From: Mark Warwick <Mark.Warwick@arun.gov.uk>
Sent: 15 December 2022 11:08
To: Maria Tomalova <Maria.Tomalova@arun.gov.uk>
Cc: Planning <Planning@arun.gov.uk>
Subject: BN/65/22/PL - Land at rear of Cedar End, Eastergate

I suppose the question is whether that activity constitutes a breach of condition. It seems to me that it does, as the new boundary with fence is shown on the 'Proposed Site Plan 0207 PO3' – an approved document.

Proposed Site Plan
1:200

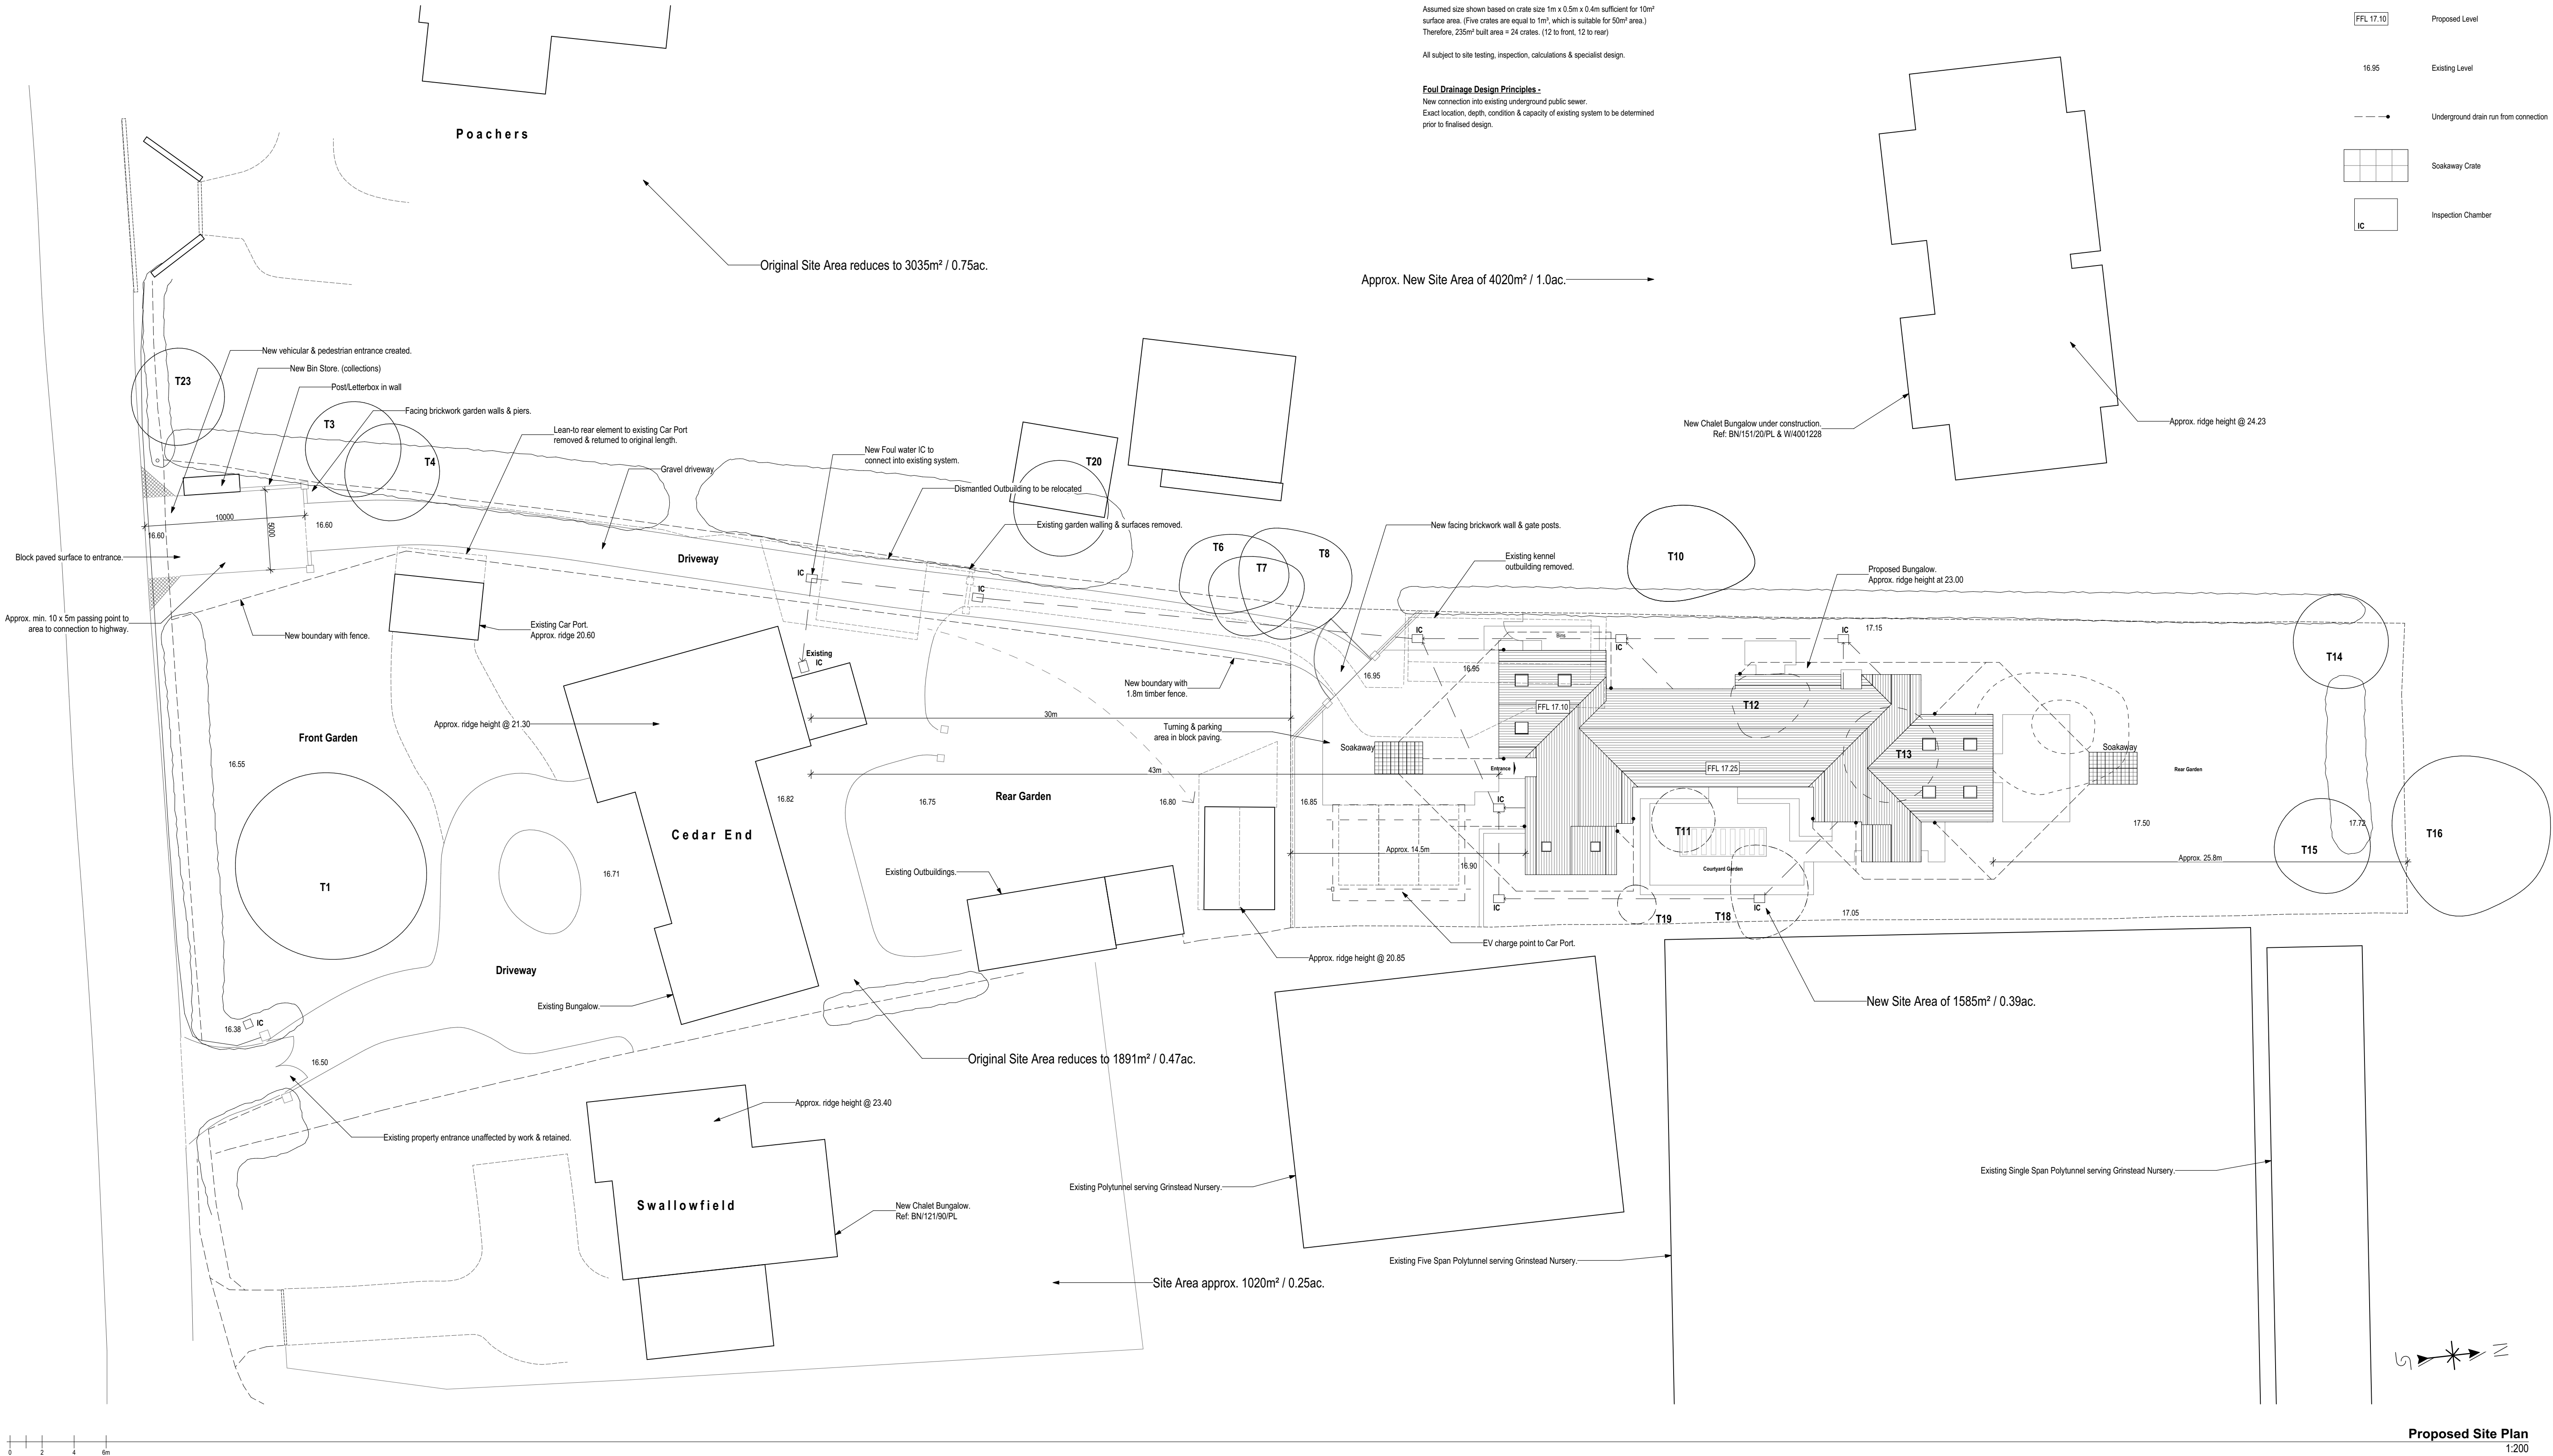
A mini digger (tracked vehicle) has been operating within RPAs of TG2 & TG5, currently being used with an auger to create post holes. This has occurred over soft ground leading to some minor compaction. Provided such activity does not recur, there ought not to be any significant impact on off-site trees. I have a verbal assurance from Kevin that this activity will cease from midday today and that the digger will be driven off-site without impacting any RPA further. The line of fence (and de-facto edge of to-be-constructed driveway serving new property to the rear) is the pink marker pegs and spray marking.

My recommendation is that the applicant and agent be notified of this breach and their failure to comply with elements of the AMS. Not a good start and does not inspire confidence.

The next stage of work should be approved tree and shrub clearance followed by installation of Tree Protection Measures. I would like to see evidence of their project arboriculturist having attended site (Appendix 4, para 4) as soon as that protective work has been initiated.
